COUNTY COUNCIL'S RESPONSE TO CONSULTATION ON THE FOLLOWING DEVELOPMENT PROPOSAL

Application No: 17/02190/F-2

Proposal: Proposed pilot training school comprising a 4 storey accommodation block, 2 storey teaching and training block, parking for cars, cycles and motorcycles, access road and landscaping

Transport Schedule

Vida + H14 + H14.4 + New Training Campus
Entrance Widening Proposal:

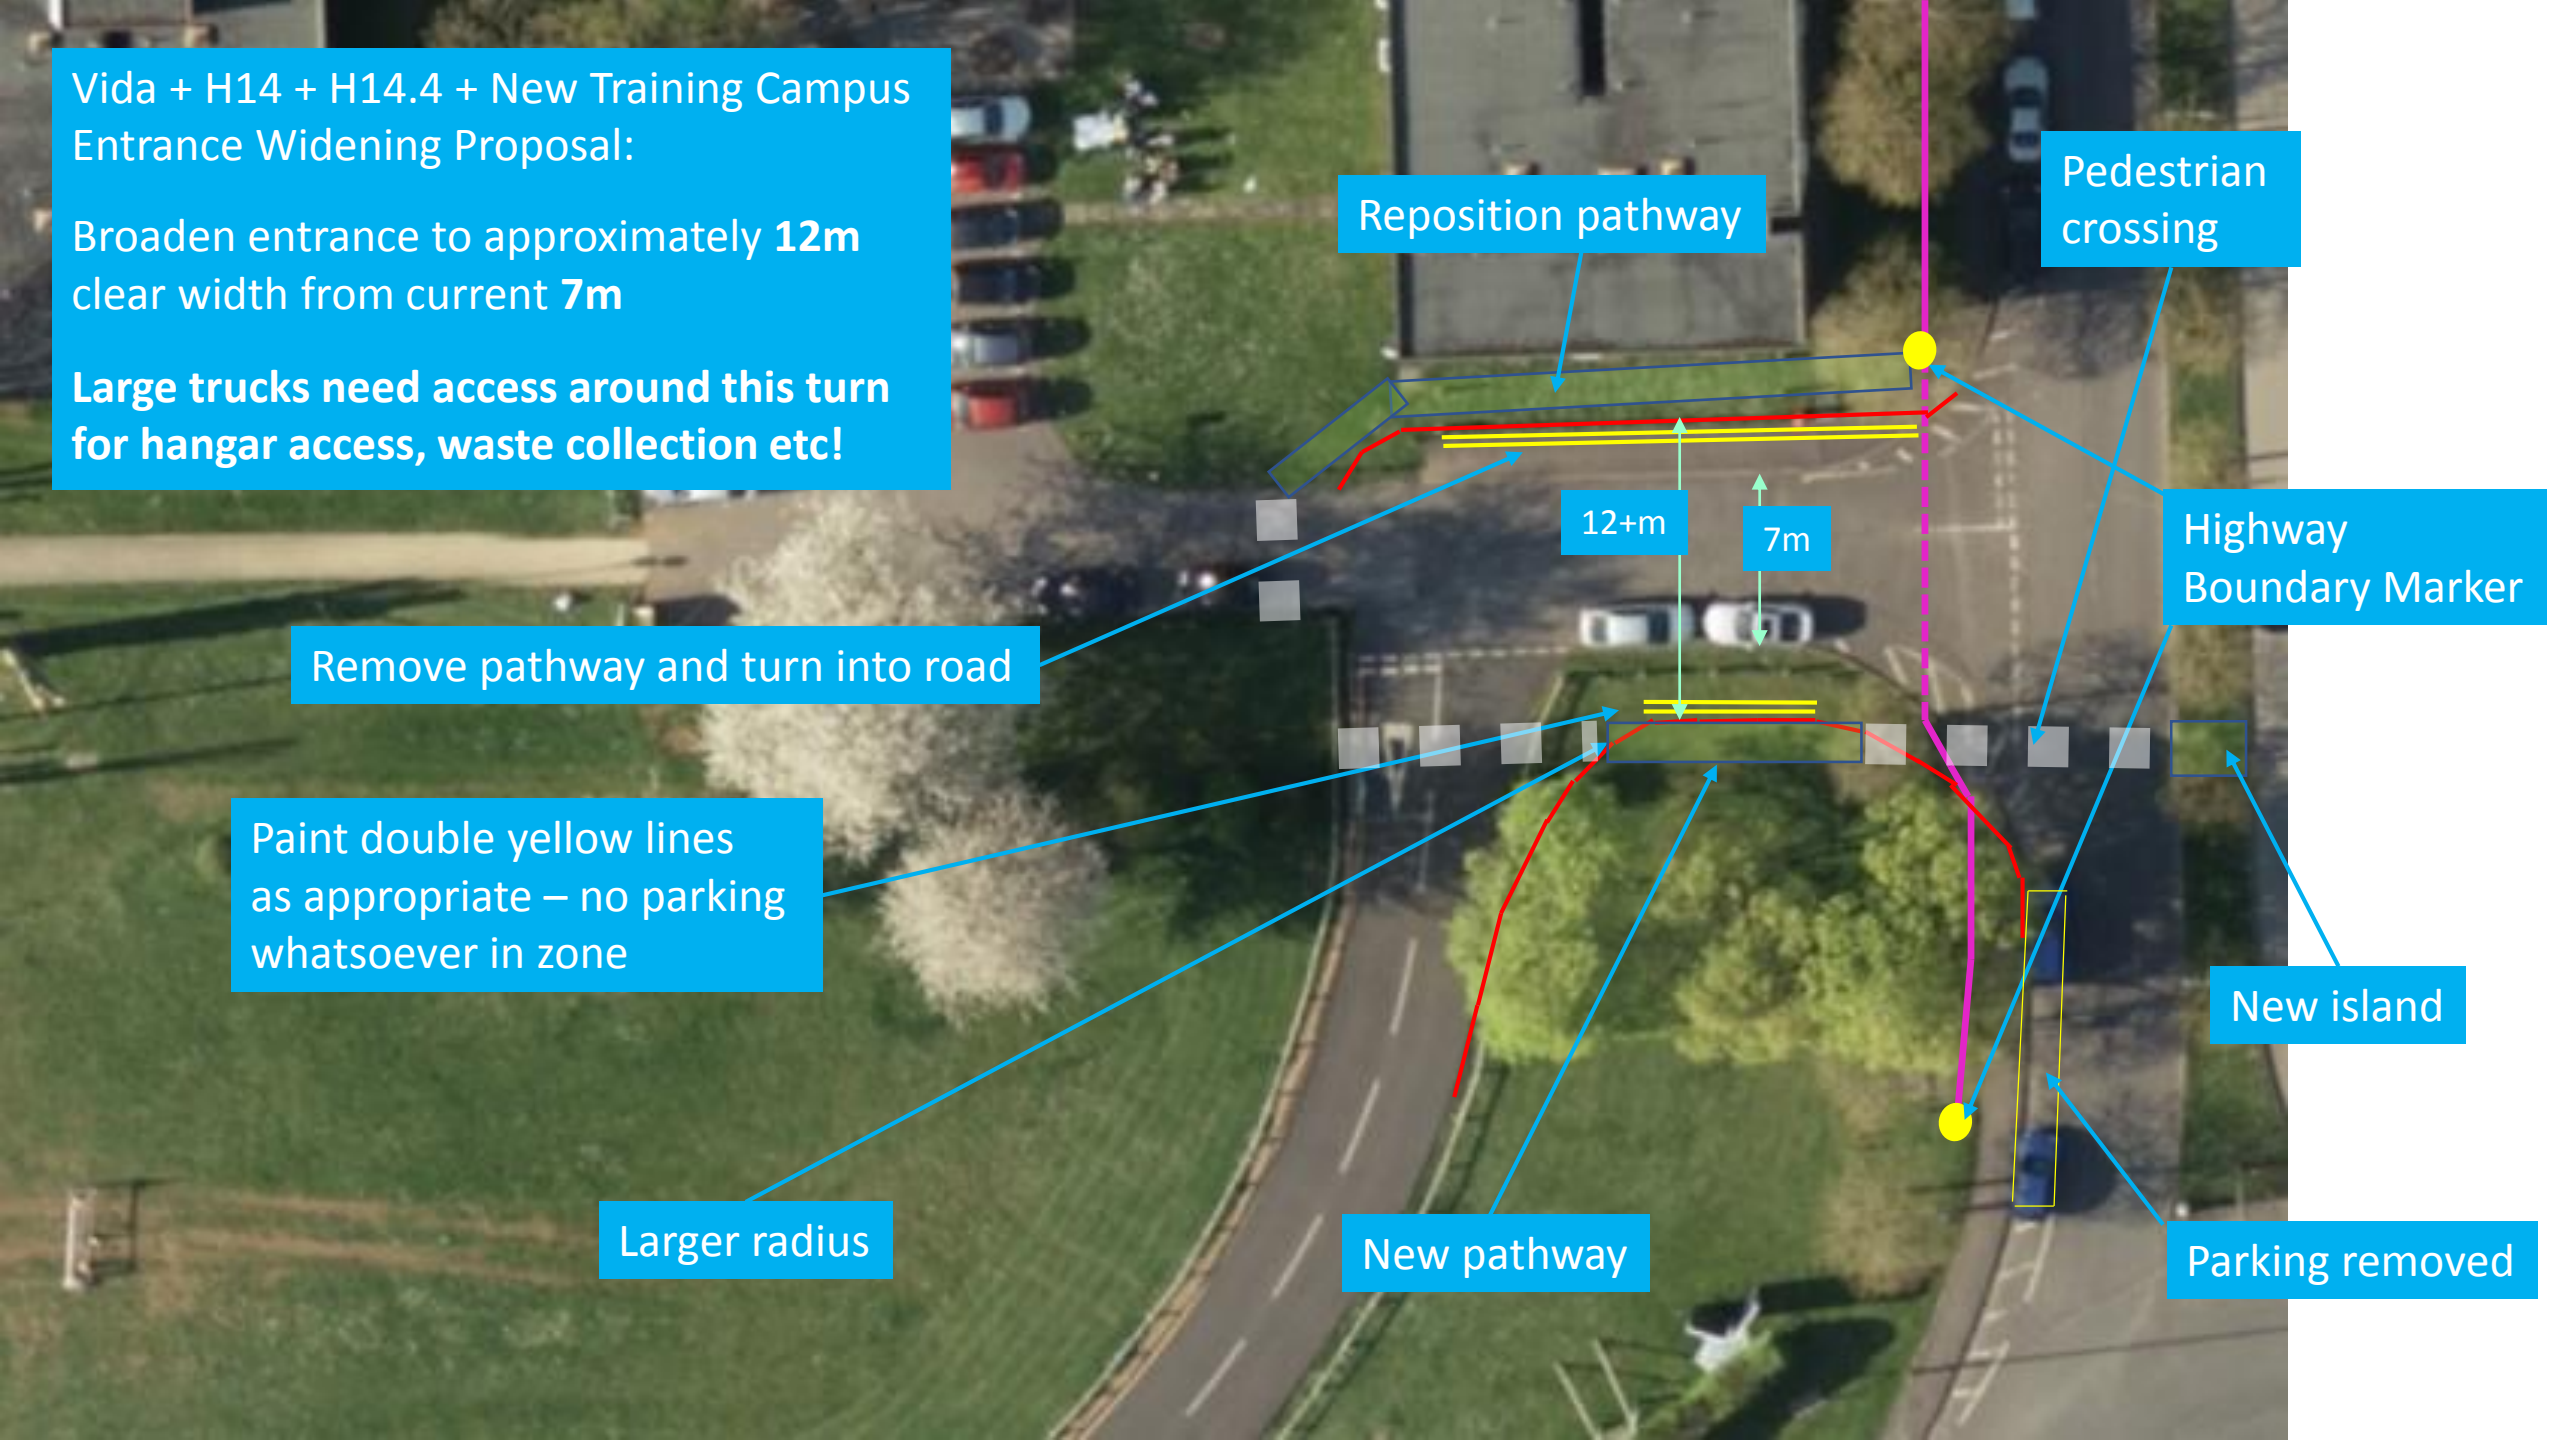
Access for the development is initially to be taken off the existing access from the Boulevard but it is not possible to tell if this is acceptable because satisfactory traffic generation estimates have not been submitted (see above). Details will need to be submitted setting out how the visibility splay to the south is achievable for the level of intensification of the access that is agreed. It is noted that there are marked car parking spaces on The Boulevard immediately to the south of the site access on The Boulevard. These are proposed to be removed as part of the S278 works for the consented development east of Evenlode Close but if that doesn't go ahead, the site access for this development off The Boulevard must include the removal of the parking to enable clear sightlines to be provided.

It is not clear how this access is to be designed and built and there is no tracking showing how large vehicles will enter and leave the site. I would expect a full bellmouth to be needed here to accommodate the possible range of vehicle movements.

It is also not clear how pedestrians would get to and from the existing footway provision to the north side of the first stretch of estate road after the junction with The Boulevard:

The onward pedestrian route from that point to the nearest bus stops on Langford Lane (buses do not run throughout the day from the stops on The Boulevard contrary to what the TS suggests). A much better solution would be for a new footway to be provided on the south side of the access road, west of the Boulevard:

This would then provide a more convenient route to the existing footway on The Boulevard. However, there is currently a run of red and white plastic barriers along the first stretch of site access road which I understand to be preventing car parking. This prevents safe and suitable access to the footway on The Boulevard and as such is blocking the public highway:

It is clear that the barriers need to be removed and in any case surely are a temporary measure. But how is the parking going to be prevented in the future without them? Double yellow lines (even though it is not a public highway) would be a good start.

Once onto the footway on the west side of The Boulevard, a route exists to and across Langford Lane (but for a distance this is in the opposite direction to the eastbound bus stop on Langford Lane) and then eastwards along Langford Lane crossing the Motor Park side road at a refuge island. Pedestrians can then continue eastwards to the point where a refuge island crossing will be provided to get to the eastbound bus stop. A more attractive and direct route would be across The Boulevard by the roundabout and then crossing Langford Lane to the east of the roundabout – it would be approximately 50m shorter to the position of the new Langford Lane refuge crossing. And it would not involve a walk in the wrong direction. The applicant should therefore provide a new refuge crossing of The Boulevard north of the roundabout by means of a S278 agreement:
